Please ask for: Rhiannon Lloyd
Email: rhiannon.lloyd@arun.gov.uk
Telephone: 01903 737637
Our Ref: BE/80/24/PDH
Your Ref:
Date: 5th September 2024

**Town and Country Planning Act 1990 (As amended)
Town and Country Planning (General Permitted development) Order 2015 Schedule 2 Part 1 Class A**

Prior Notification for a Permitted Development (Householder)

Development: Notification under extended permitted development rights for a single storey rear extension measuring 4 metres from beyond the rear wall of the dwellinghouse, with a maximum height of 3.5 metres and an eaves height of 2.8 metres.
Location: 38 Sherwood Road Bersted PO22 9DR

PROPOSED ELEVATIONS.

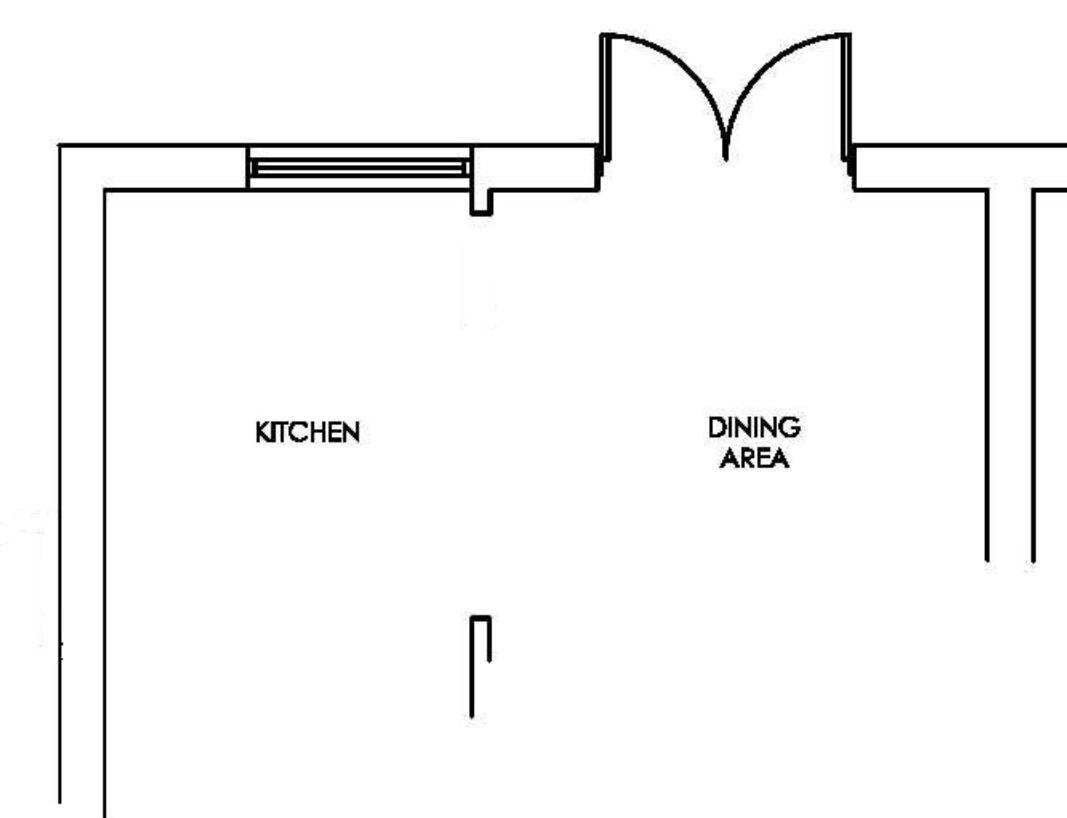
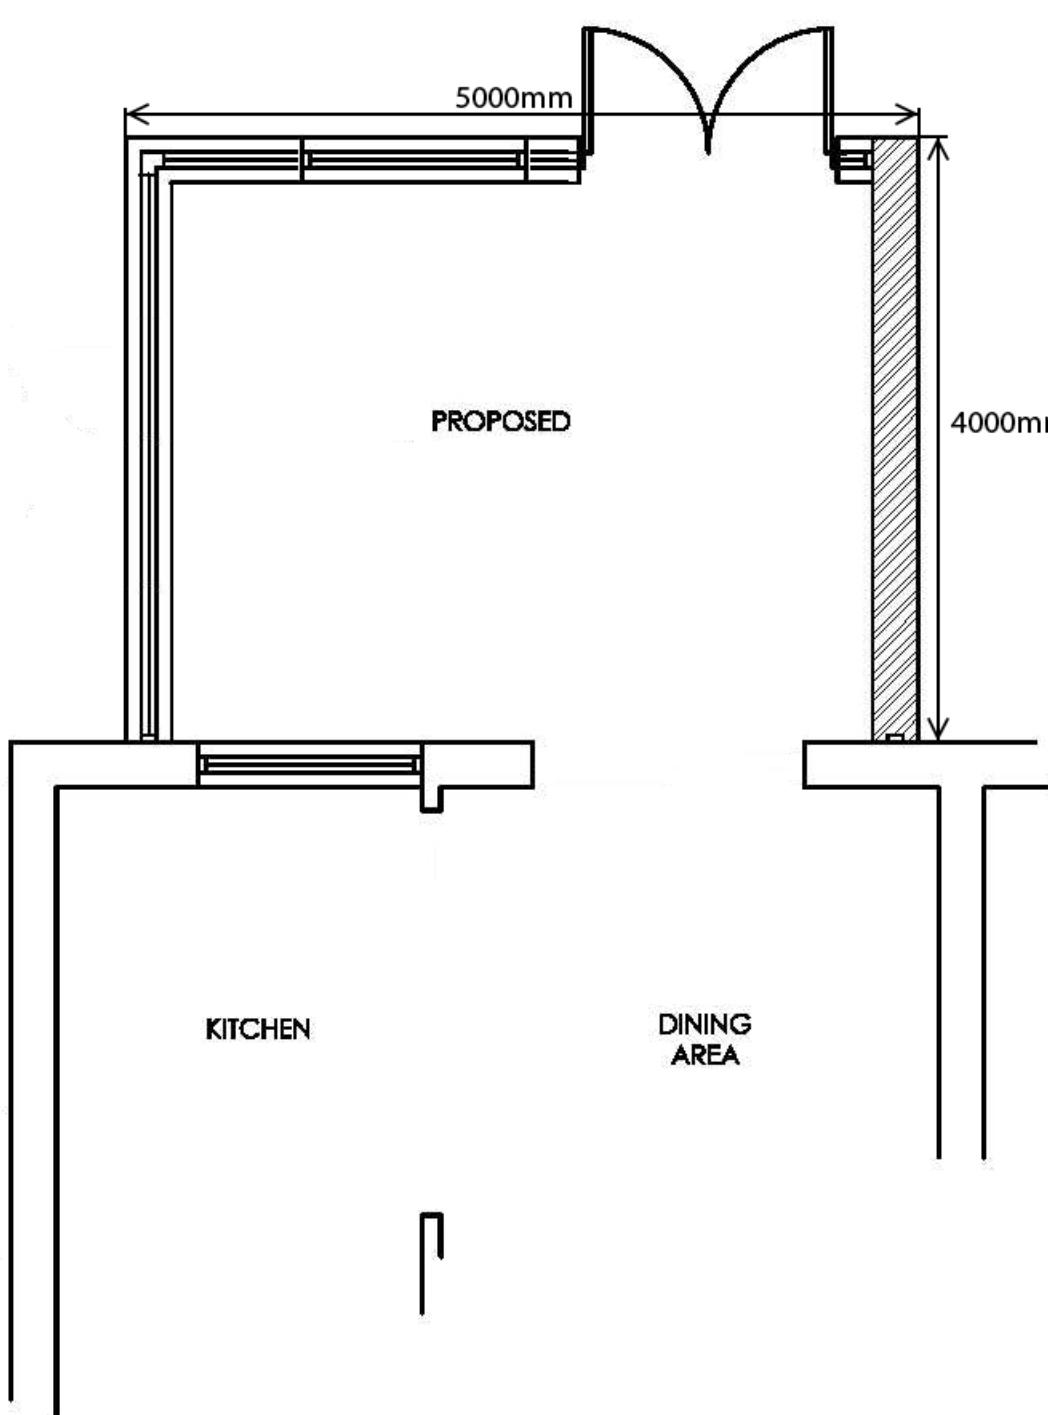
Elevations

Please provide an amended plan sheet indicating the proposed height of the extension, as well as the length and width already shown.
